**RE: MODIFICATION TO PROJECT APPROVAL S07/00079**

As discussed with your Mr Ben Holmes on 25 July 2007, Macquarie Generation seeks to obtain approval for several modifications to the above project under Section 75W of the Environmental Assessment and Planning Act 1979. The modifications requested and the reasons for the changes are described below.

**Figure**  
Plashett - Revised Outlet Arrangement

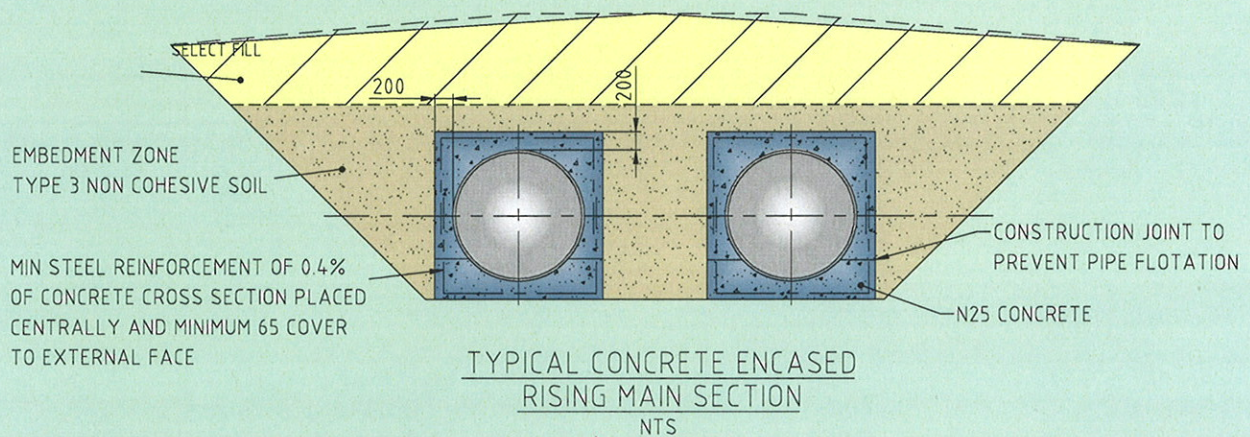
Following a design review, Macquarie Generation proposes to shorten the pipeline by one kilometre, by terminating the pipeline at the point at which it meets the shore of Plashett Dam. This last section of the pipeline was to run along the shore of the dam to the existing outlet point for discharge. The change in the pipeline route is shown in **Appendix A**.

Typical Sections for Twin 1.8m Pipes

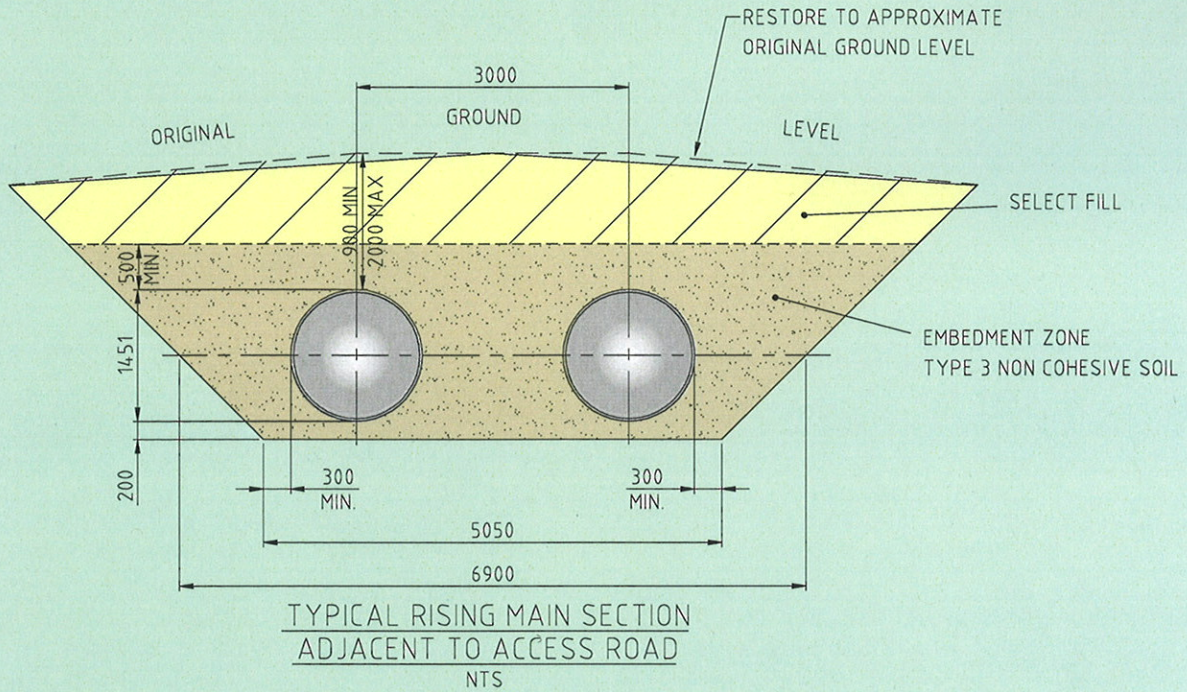
Macquarie Generation now proposes to lay the pipes under the ground. The decision to change the position of the pipe was based on being able to procure pipe suitable for underground use more quickly than that for above ground use. This is seen as advantageous to the project. This change will provide positive environmental effects, including reduced visual impact and reduced area of long term disturbance. Construction time will also be shorter as the need to install footings for the above ground pipelines requires more time than for trenching & installation of the pipelines below ground.

Appendix B: Plates 1 to 4 showing view of Project from various vantage points

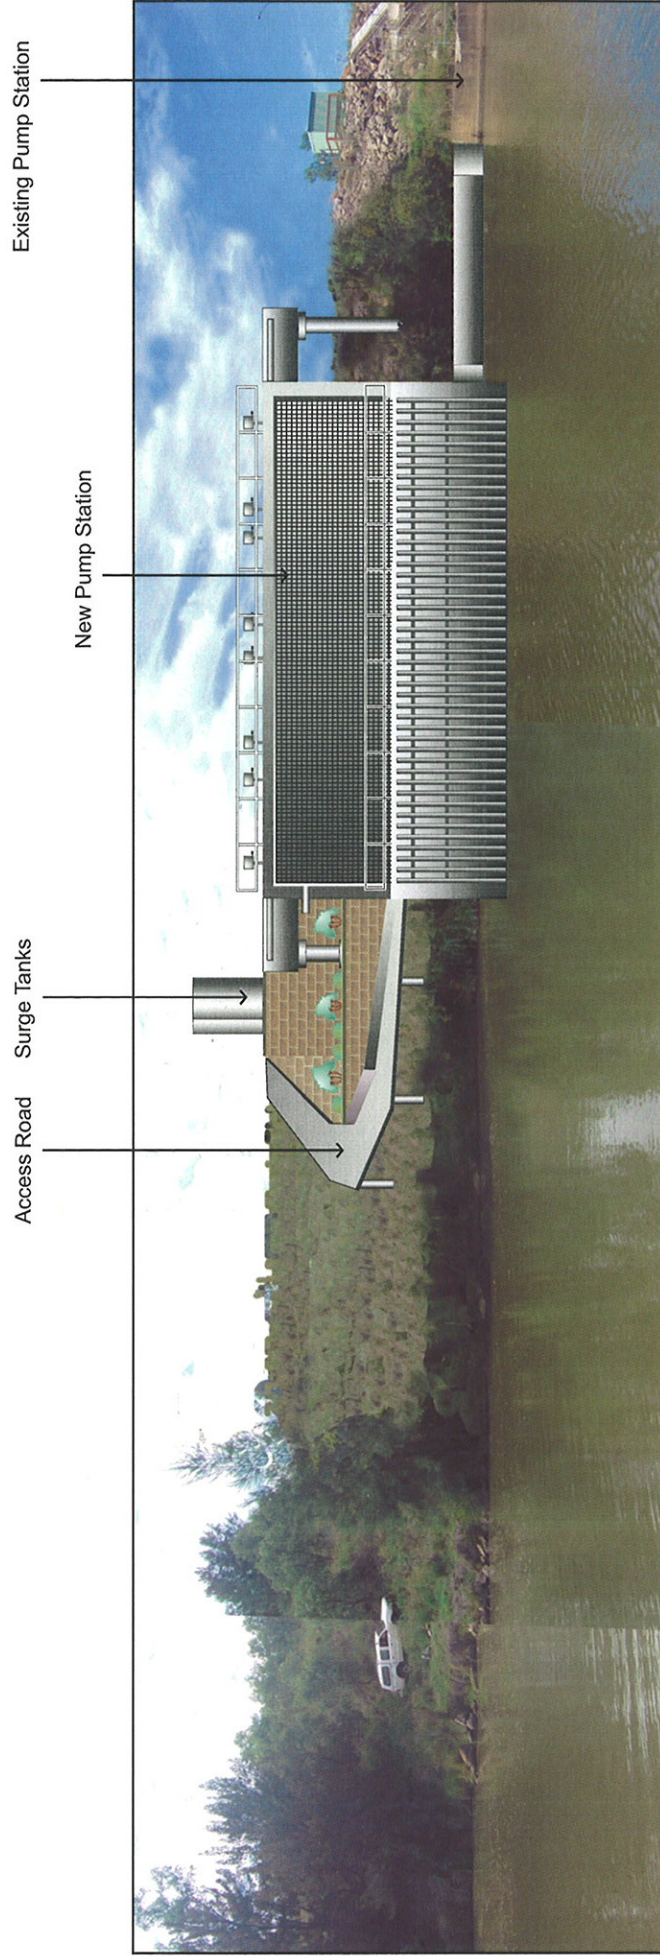
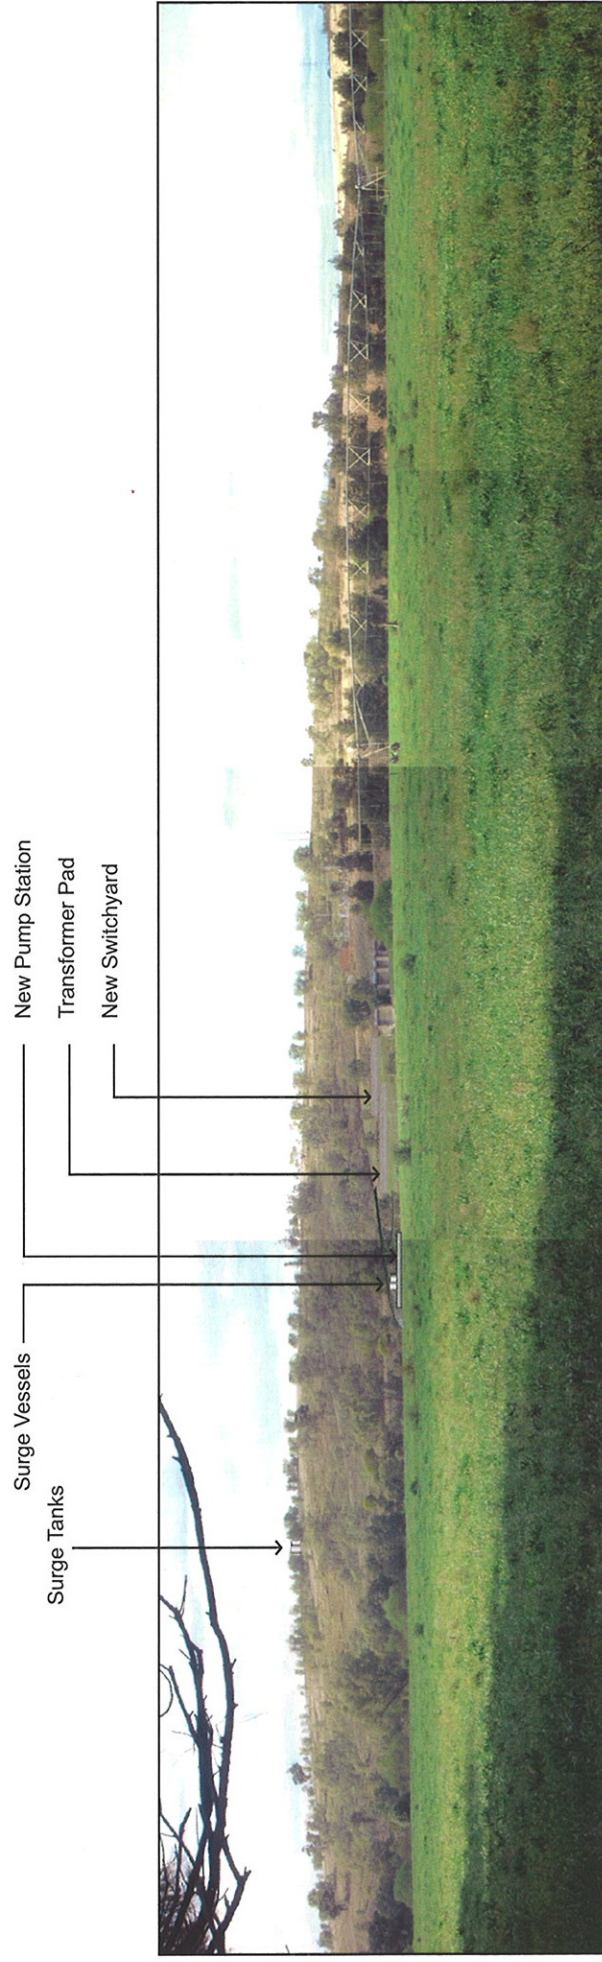
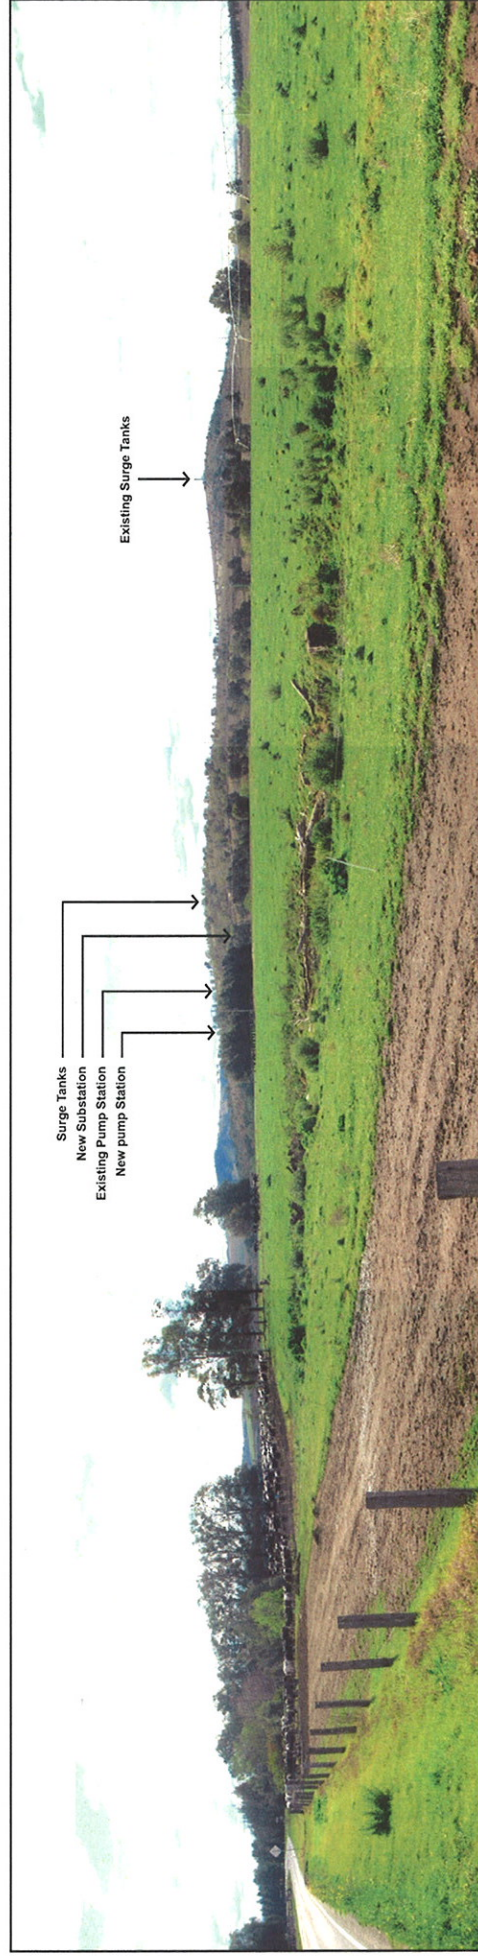
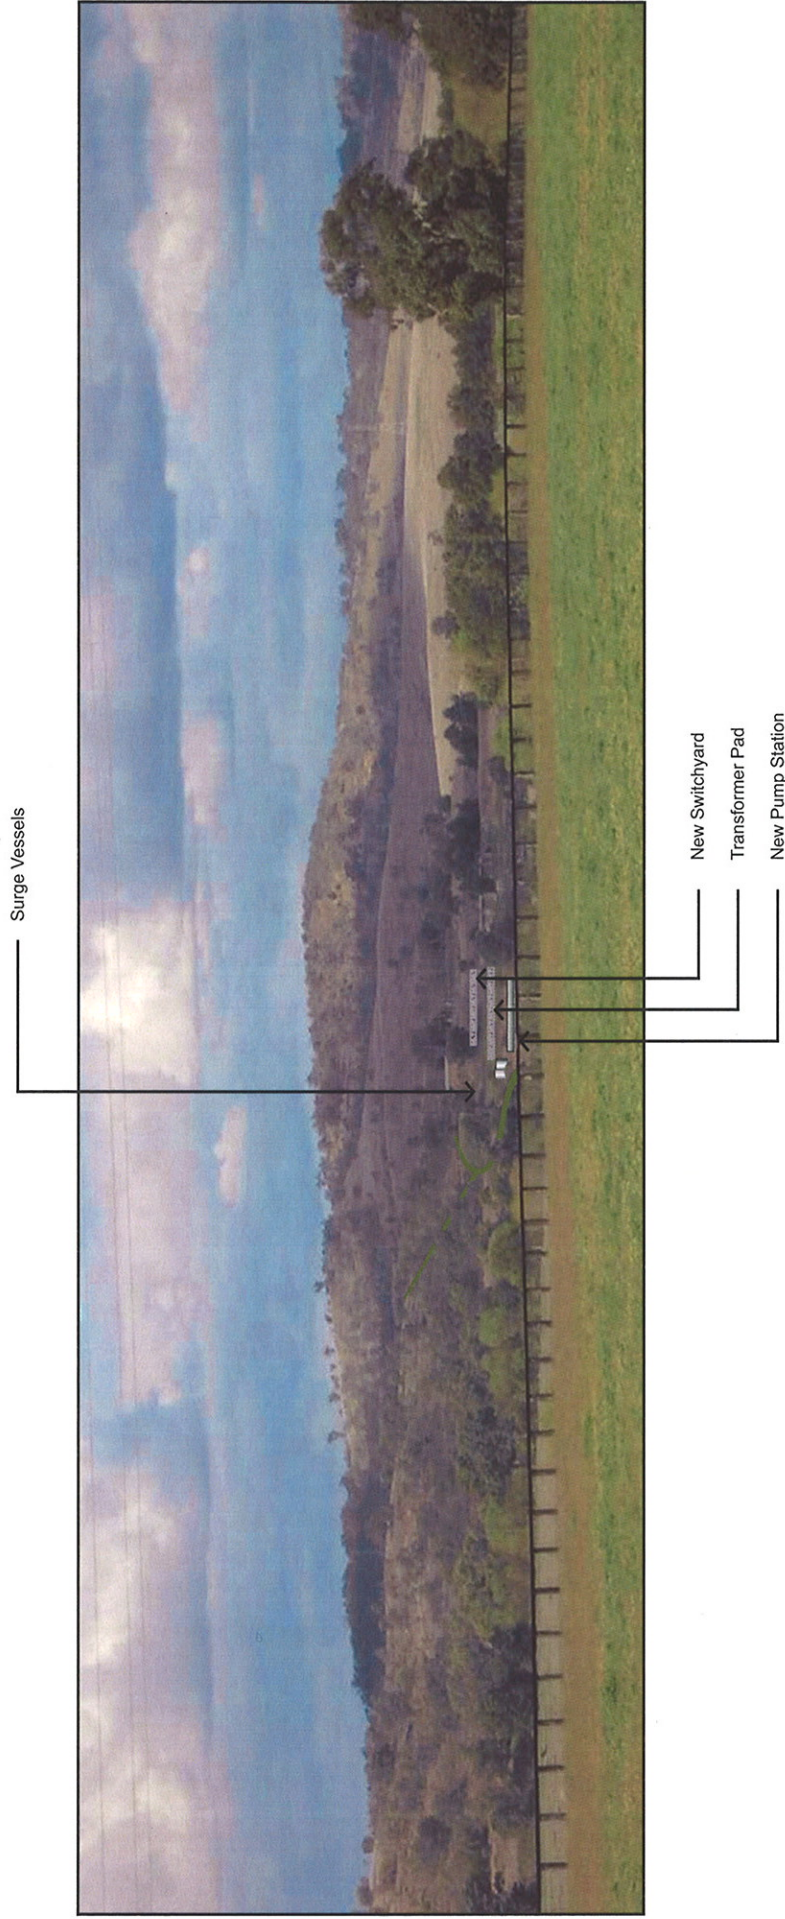
As the surge tanks are to be constructed wholly within the previously assessed corridor and adjacent to the proposed pipeline the reduction in visual amenity is the only environmental aspect that could potentially be impacted. To assess this aspect, four (4) photomontages were developed showing the proposed works from various vantage points. The photomontages and the viewing points are shown in **Appendix B**.
